Ribble Valley Borough Council
Housing & Development Control

Application no: **3/2022/1129**

Address: **Bridge Hey Wood Caravan Park Dunkirk Farm Read BB12 7RR**

Proposal: **Retrospective change of use with minor engineering works and associated landscaping works for the reuse of the former railway embankment and track bed to form an informal recreational amenity area in association with the adjacent holiday park.**

Pedestrian Access route from Caravan Site Scale 1:1200

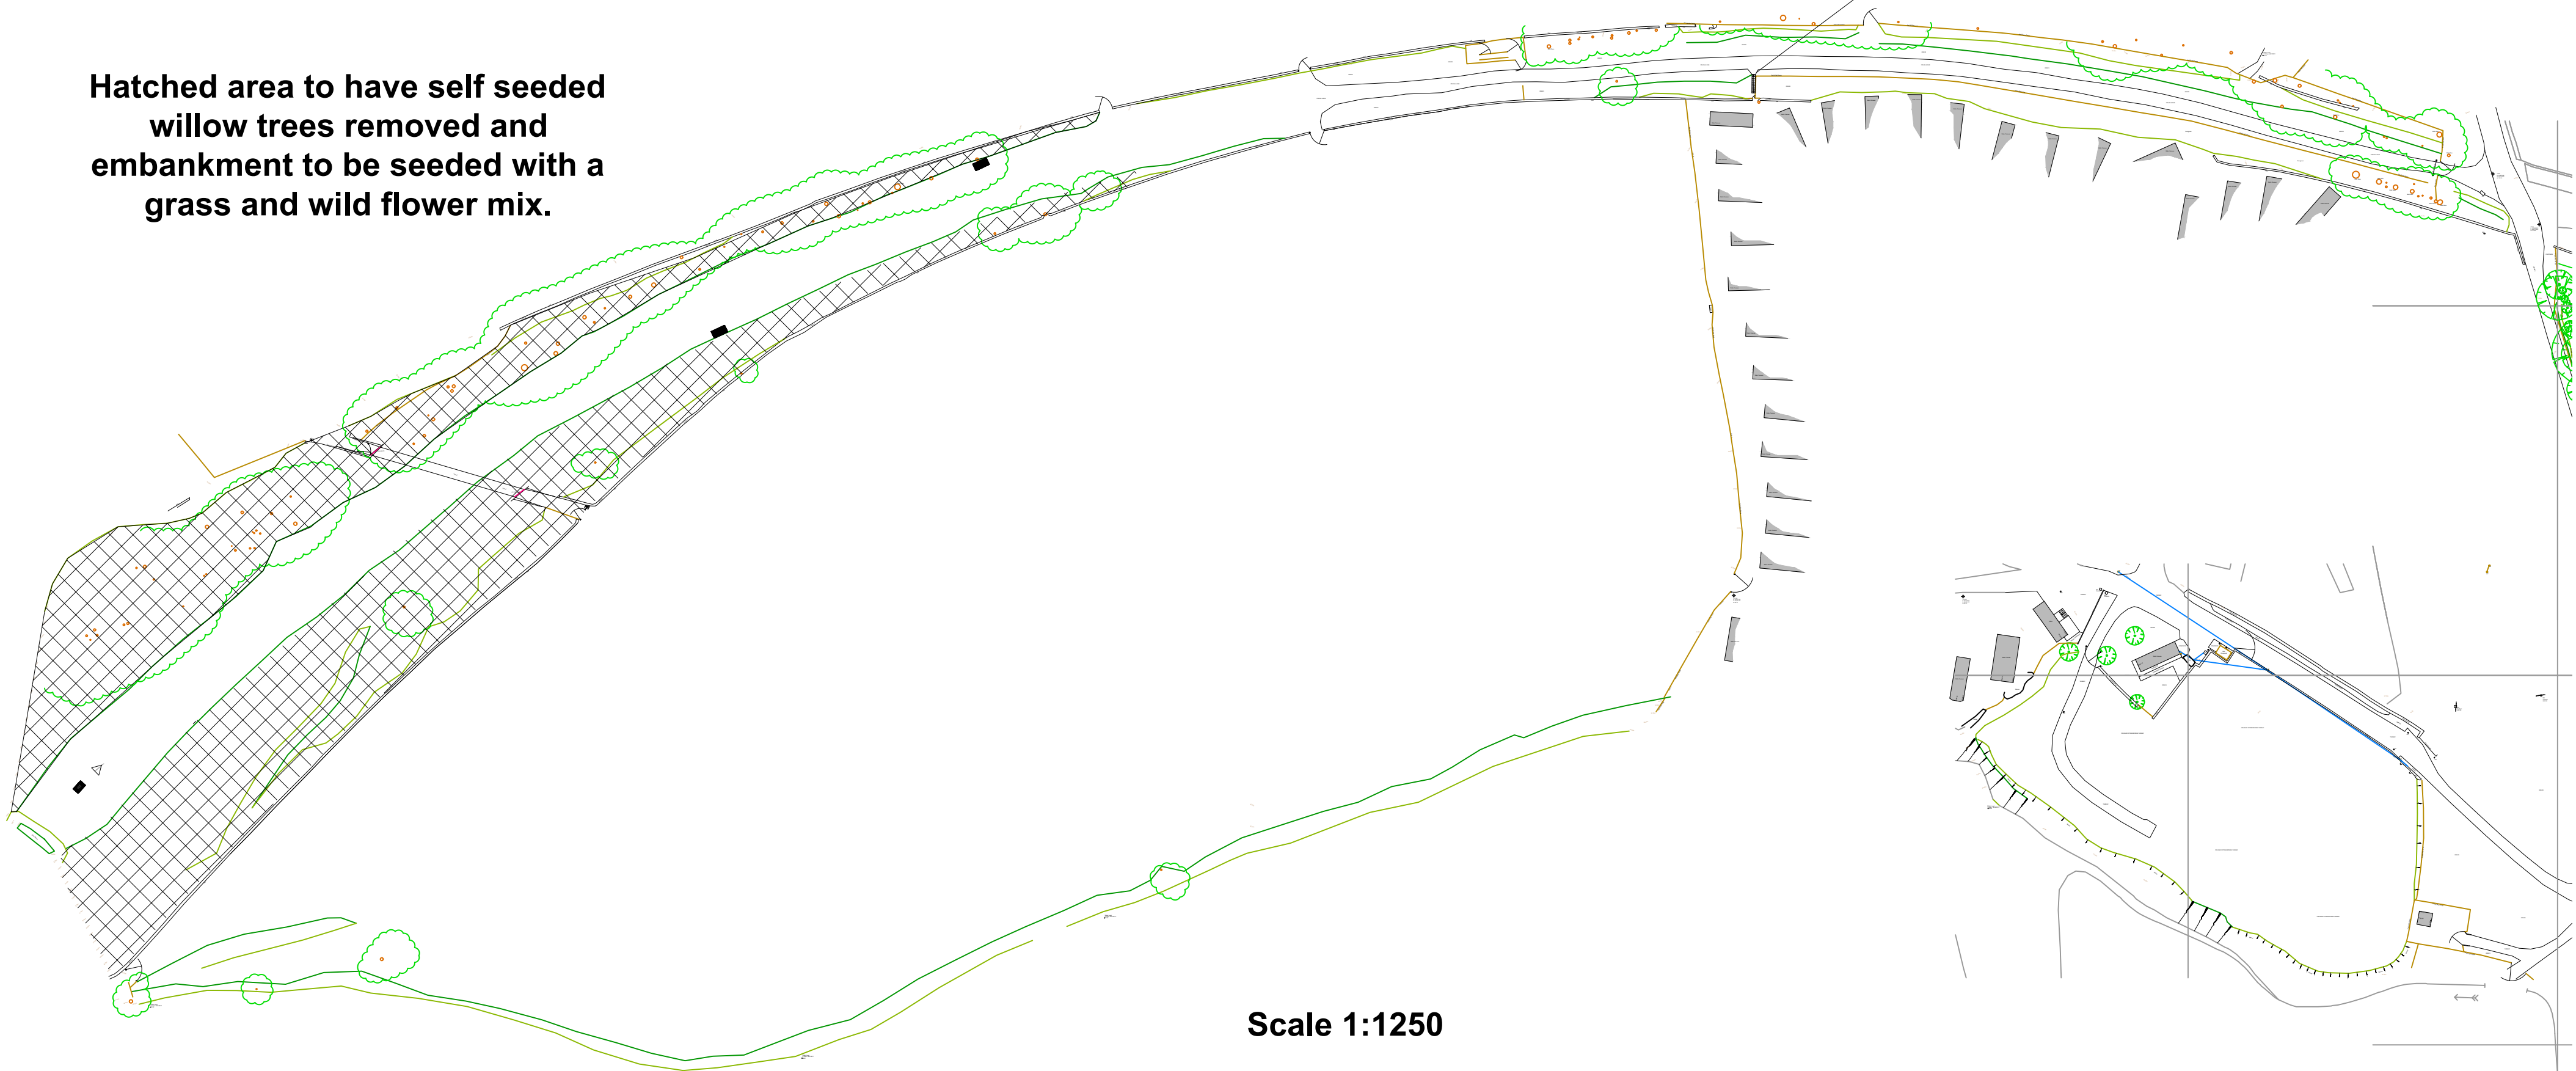
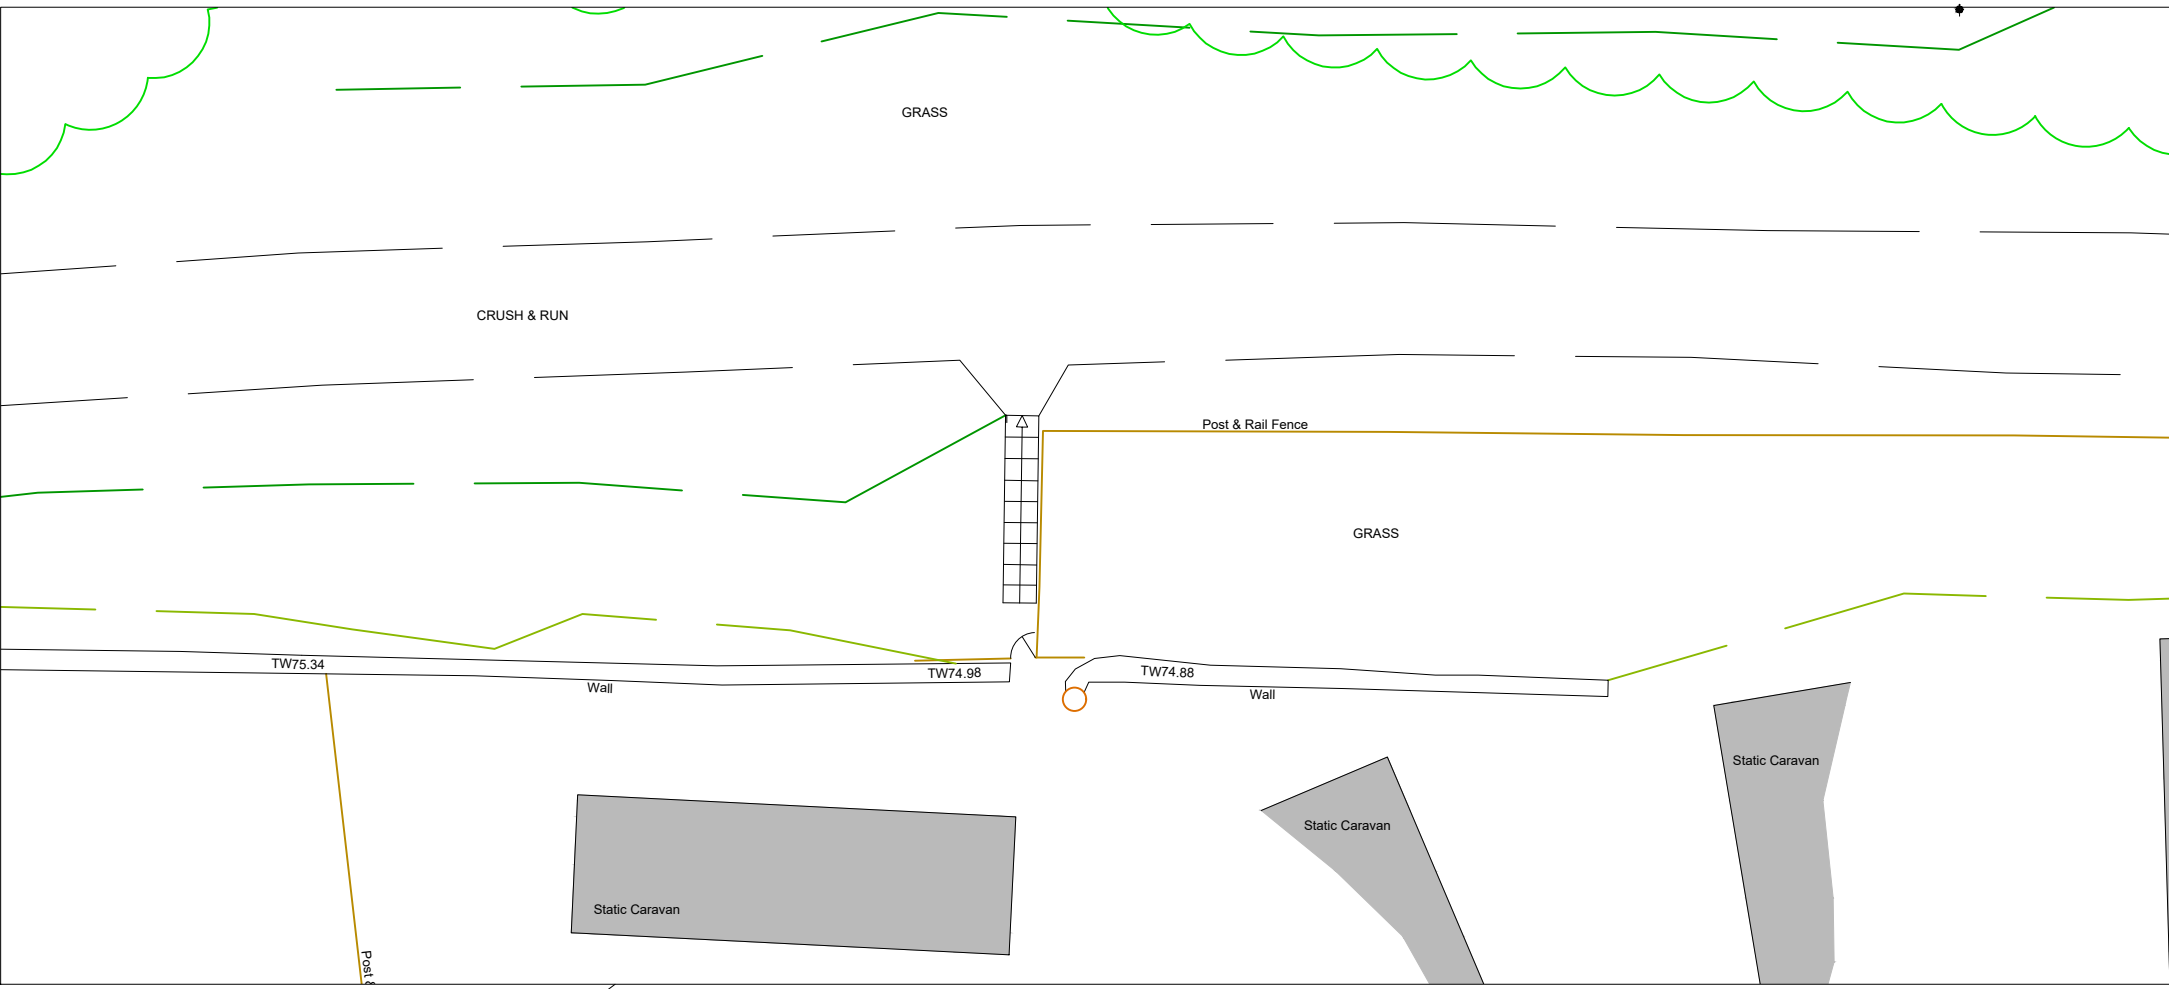
The LHA have reviewed the supporting information and are aware that the proposal will use a part of an existing track leading from the caravan park as part of the nature trail.

The LHA require the LHAs Public Rights of Way team to comment whether the usability of the trail is suitable for the proposal.
